Portishead Branch Line (MetroWest Phase 1)

Planning Inspectorate Reference: TR040011

9.3.3 ExA.SoCG-EA.D7.V5 – Statement of Common Ground

Date: 14 April 2021

Drawing Title: CATTLE CREEP PROPOSED GENERAL ARRANGEMENT SHEET 1 OF 2

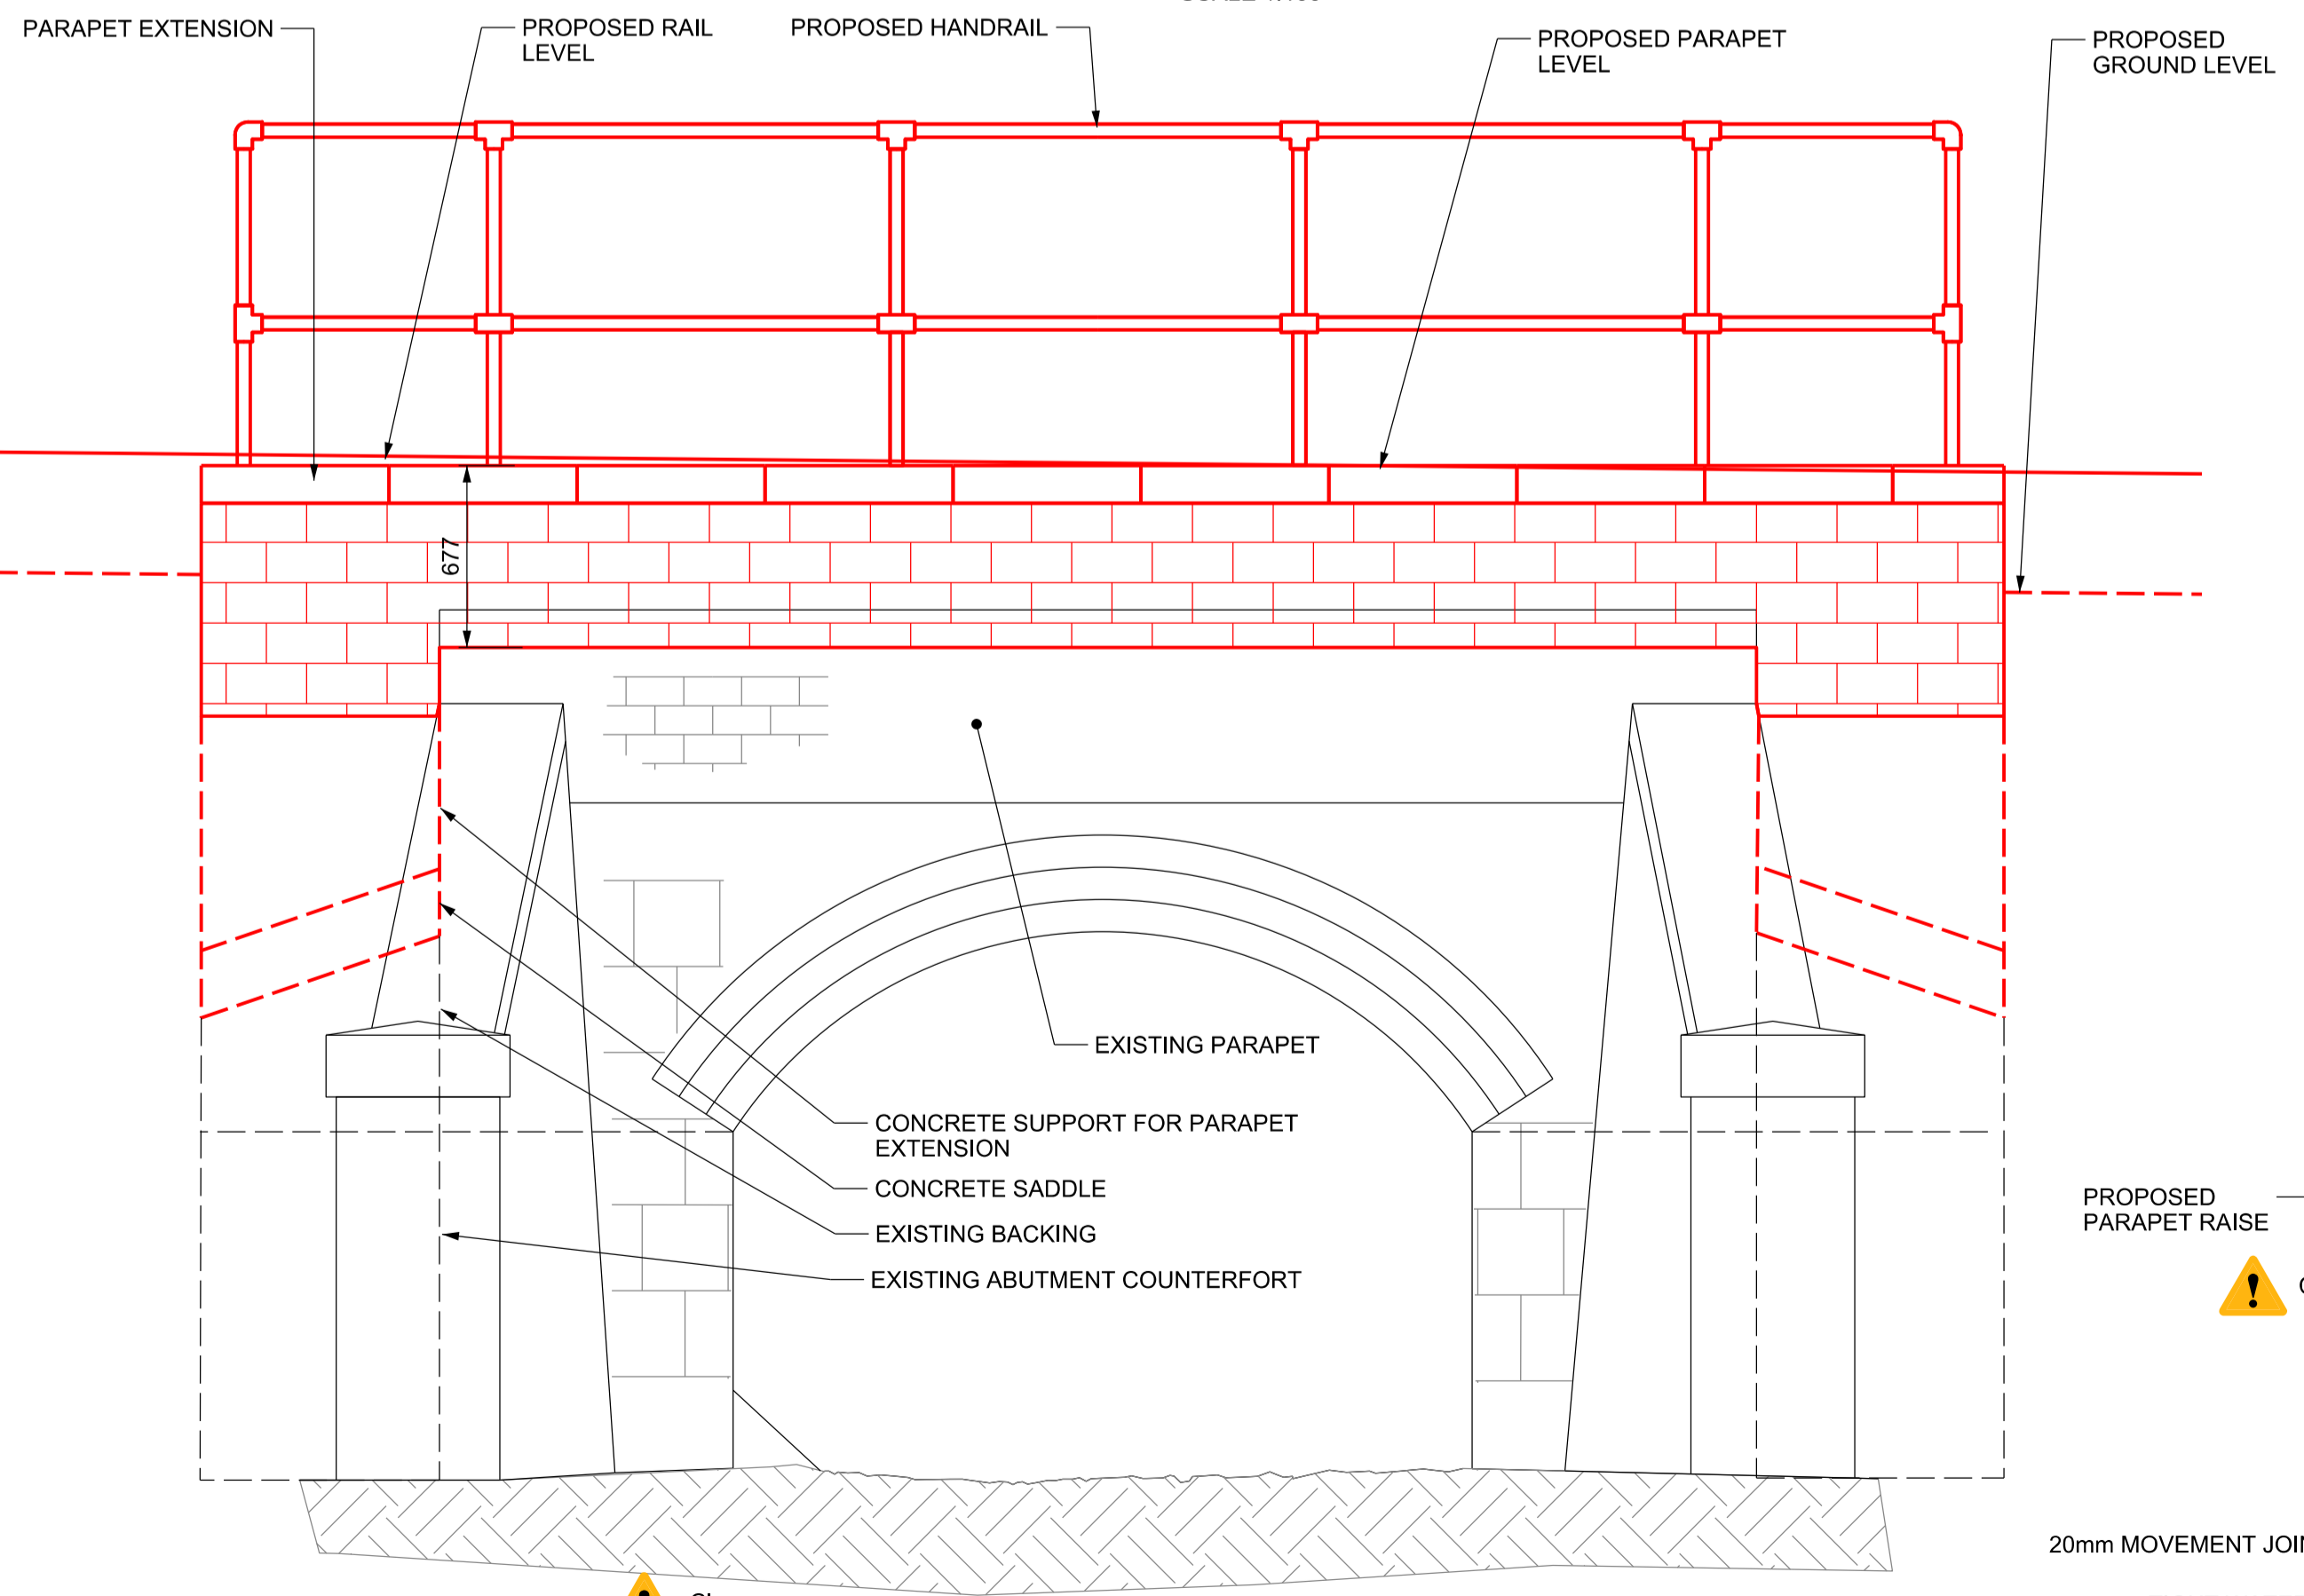
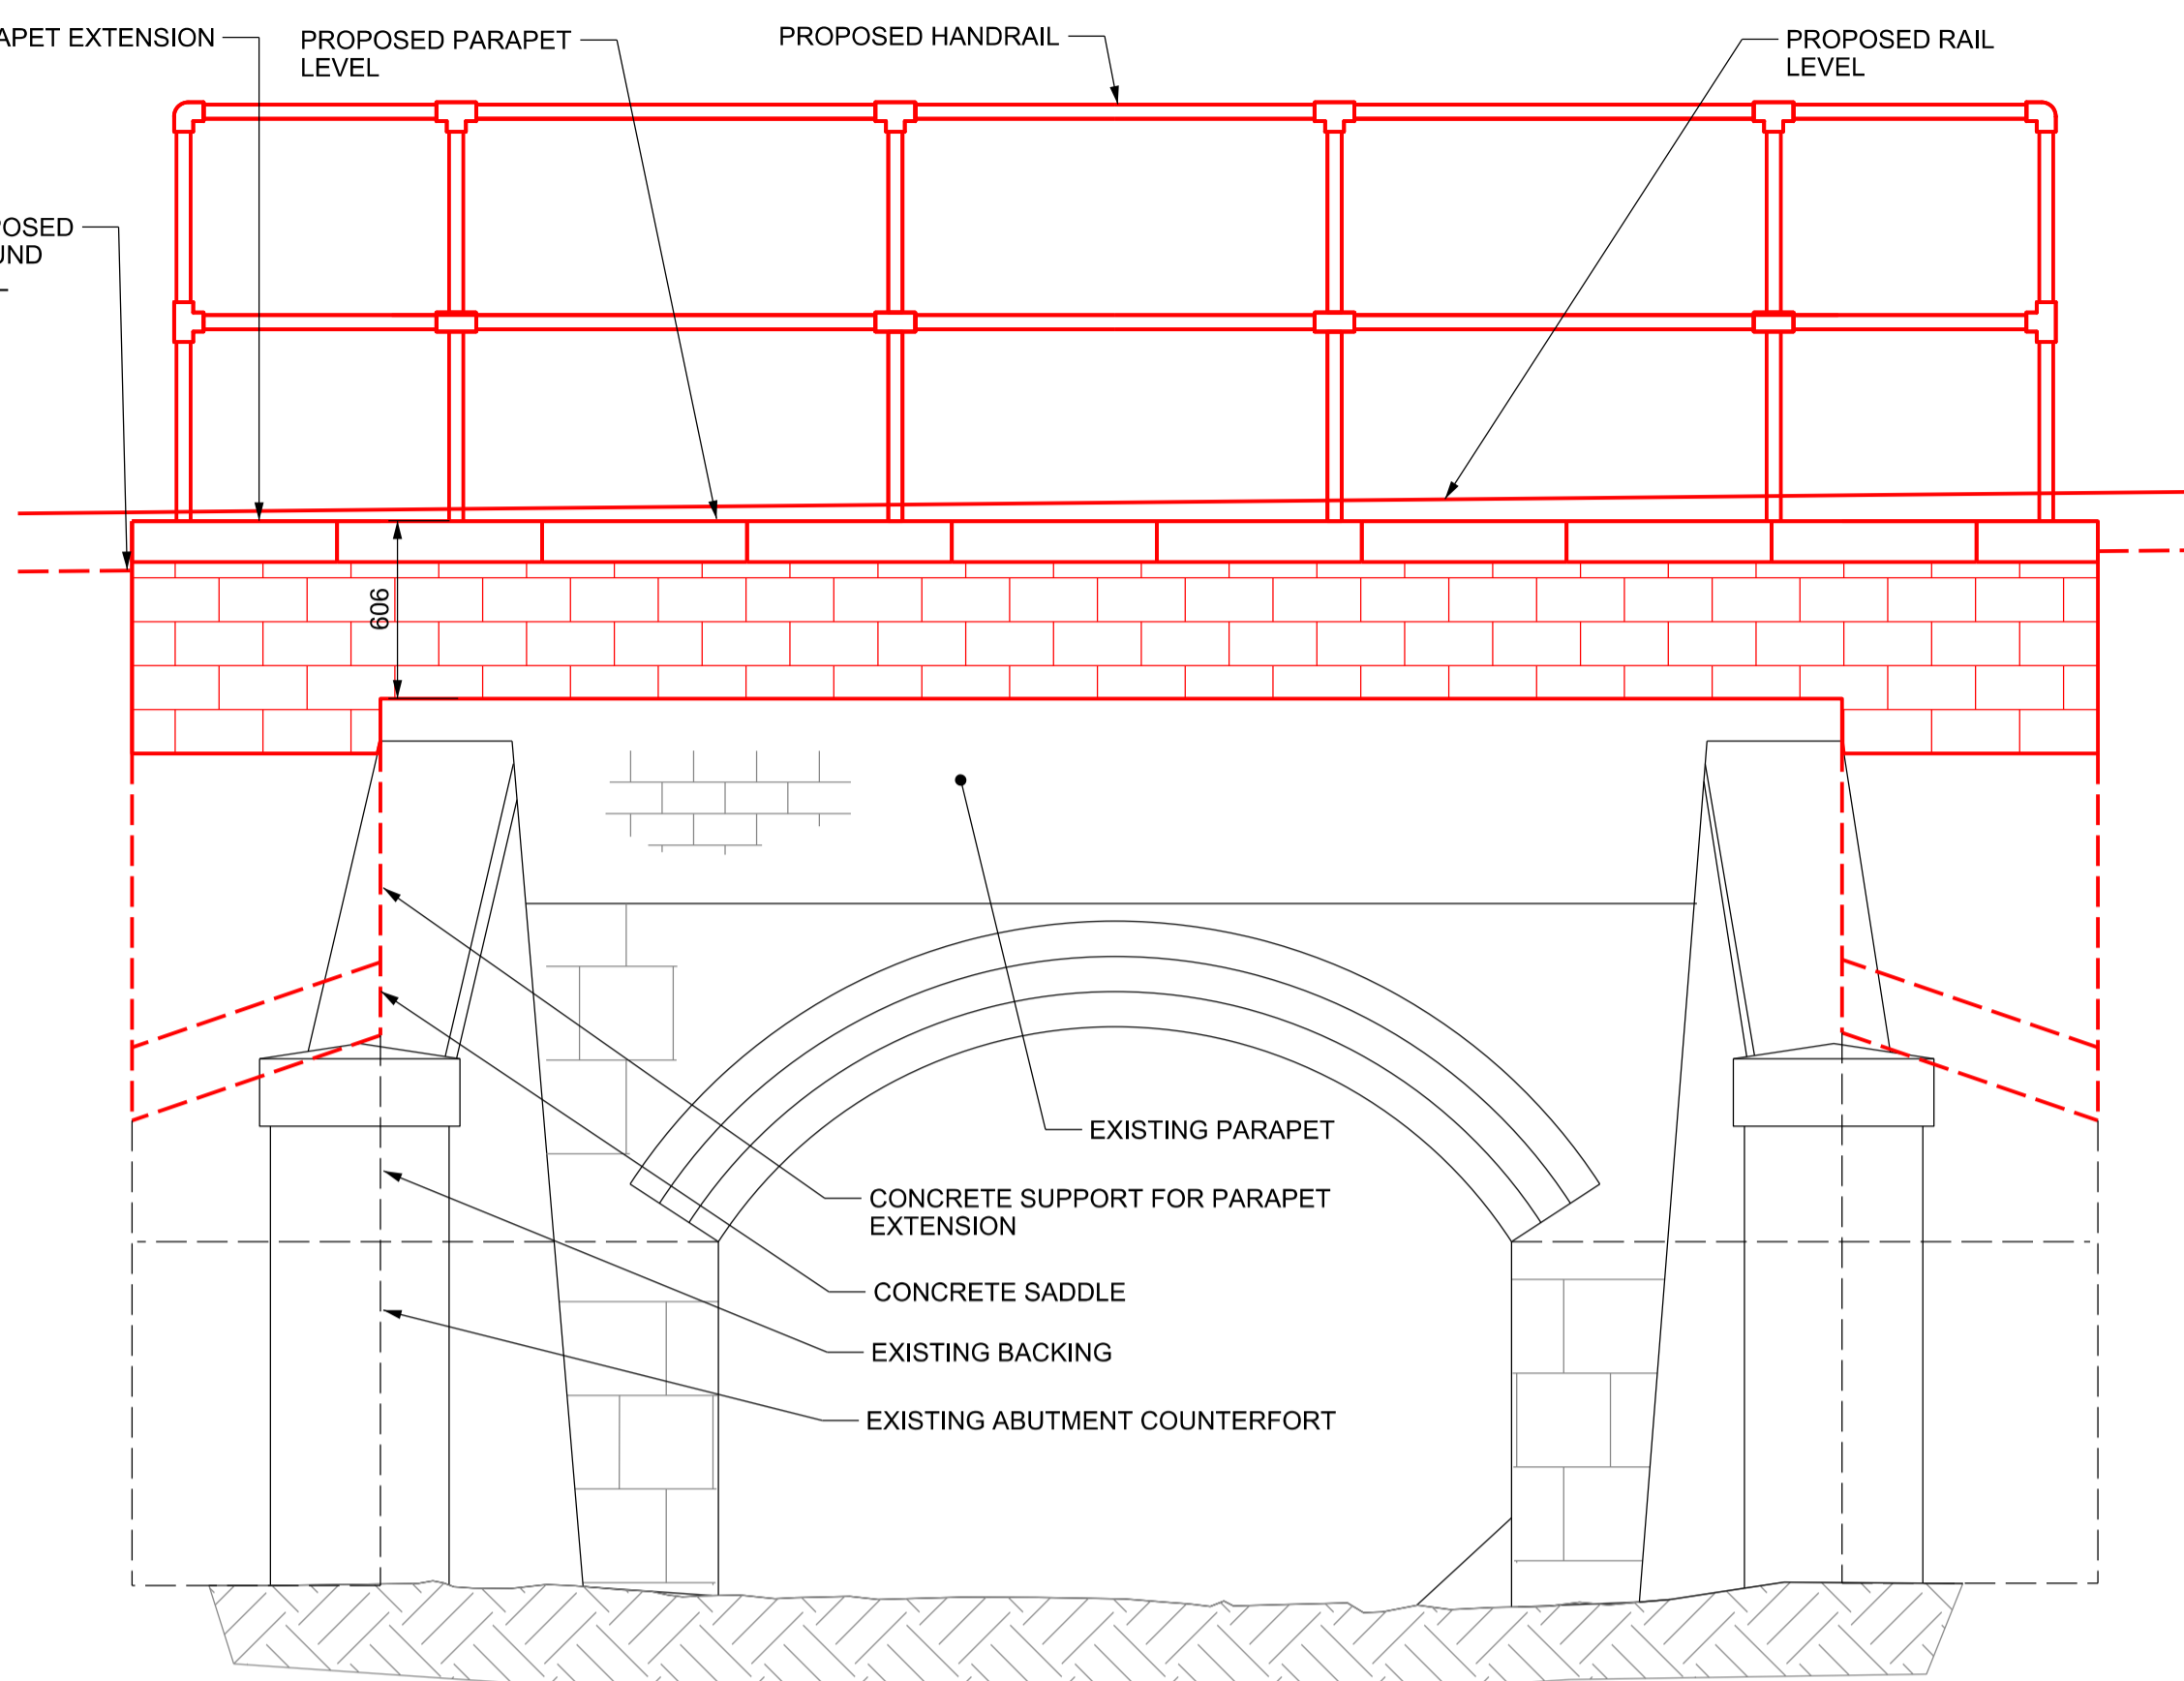
5.1.9	Easton in Gordano Stream	<p>The EA agrees that specific flood compensation is not required however, this relies on a flood relief channel in the form of a farm access track running under the railway line. As a result, appropriate provisions are required within the DCO.</p> <p>By email dated 30 March 2021 the EA state "Providing the means to secure the ground level and arch</p>	<p>There are no plans to block Cattle Creep access track and it will be maintained in its current form.</p> <p>The Applicant points out that sub section 2 of the new requirement 33 provides the comfort the EA requires.</p>	<p>Issue Resolved: The EA has accepted new requirement 33 for Cattle Creep access track within the dDCO with an amendment to retain the works thereafter. as follows:</p> <p>33.— (1) Work No. 1B must not commence before the undertaker has provided to the relevant planning authority and the Environment Agency a topographic survey setting out the existing ground levels at Cattle Creep bridge, Easton in Gordano.</p> <p>(2) Works to Cattle Creep Bridge must be carried out and retained thereafter in accordance with the principles set out in the Cattle Creep Proposed General Arrangement drawing and in particular the arch of the Cattle Creep Underbridge must not be altered and the ground level beneath the Cattle</p>

Ref	Topic	Environment Agency position	Applicant position	Status (Issue Resolved/Issue Outstanding)
		design is confirmed, the Agency can confirm the issue is agreed."		Creep Underbridge must not be raised without the prior consent in writing of the relevant planning authority following consultation with the Environment Agency and (if relevant) the lead local flood authority.
